From: Michael Eastham
Sent: 23 March 2018 10:00
To: 'Clark, Robert'
Cc: Planning.Responses
Subject: FW: LU/121/17/RES - Phase 2 - North Littlehampton Strategic Development Area (SDA)

Anomalies persist in page 16 and 17 of the Wyg Noise Report dated February 2018. That last paragraph to page 16 detailing the location of sensitive receptors needs correction in that:-

SK02 Site Layout and Receptor Locations

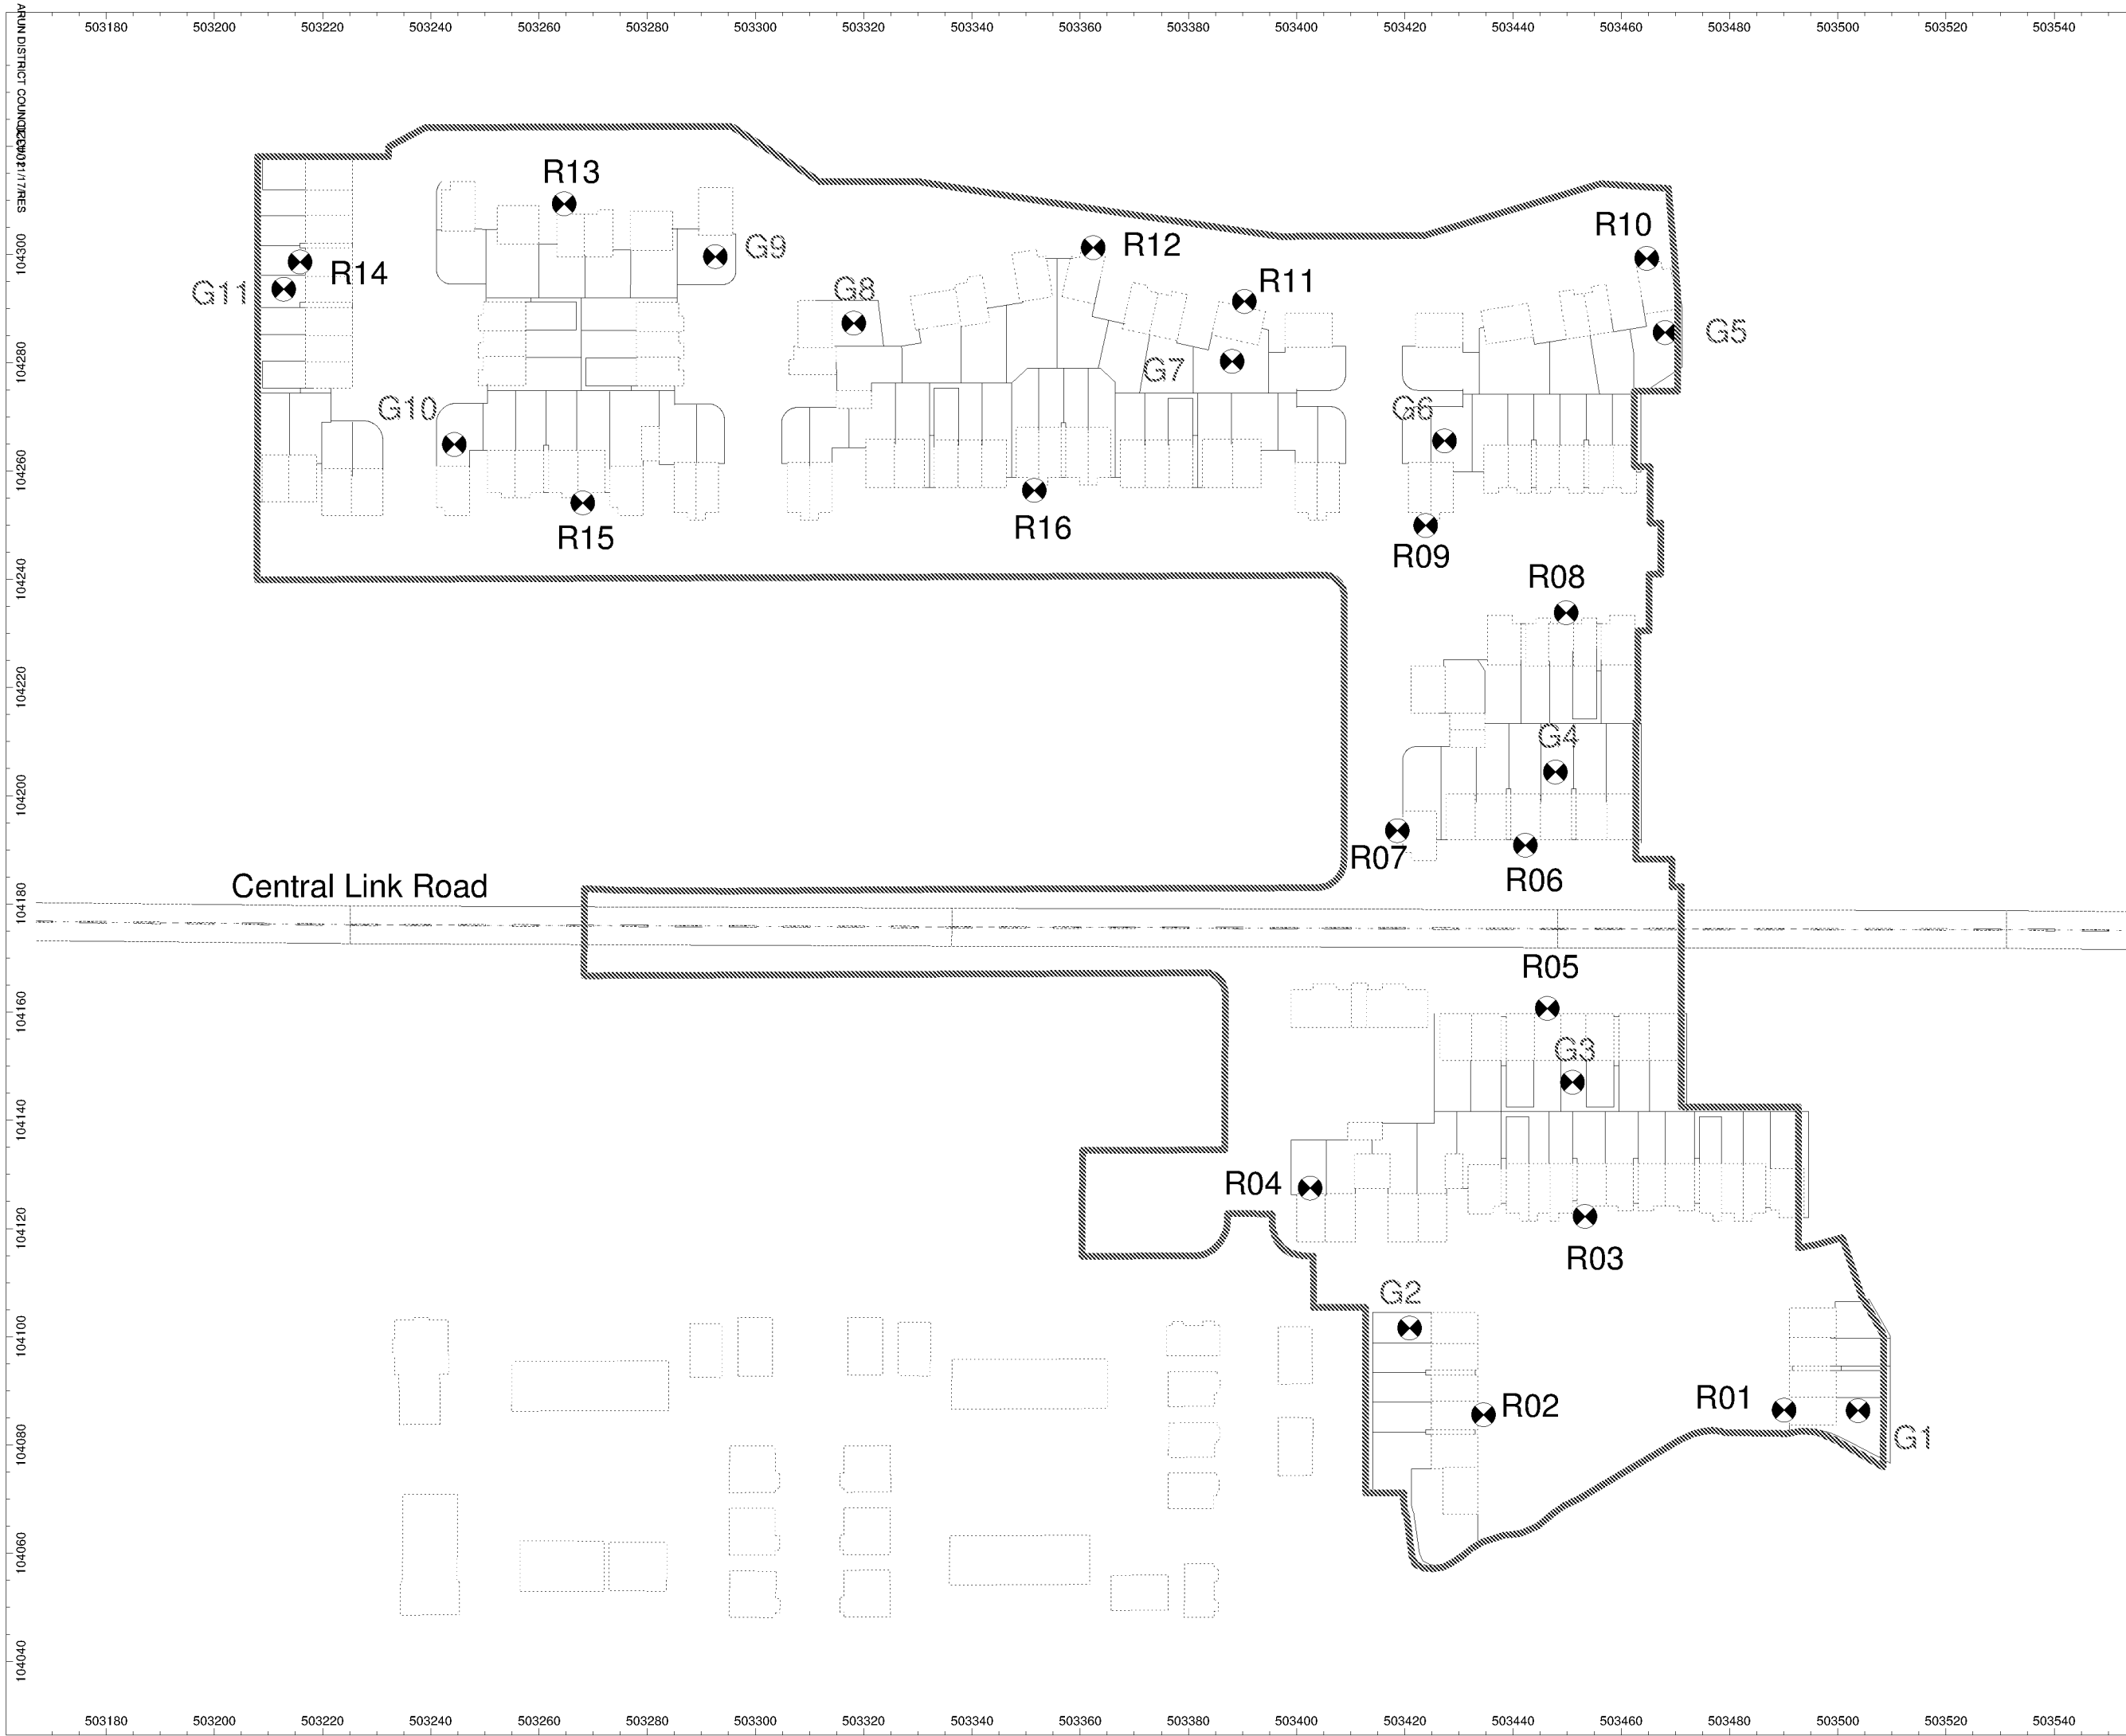
Plot 82-86: The applicant has referred to living rooms being shielded. He has omitted the fact that sensitive rooms ie the bedrooms are exposed to the effect of the Central Link Road. This detail should be added in.

Plots 99-100. These consist flats 95-100. Whereas it is stated that bedrooms are exposed to the effects of the Central Link Road this should be adjusted to include bedrooms **AND living rooms**.
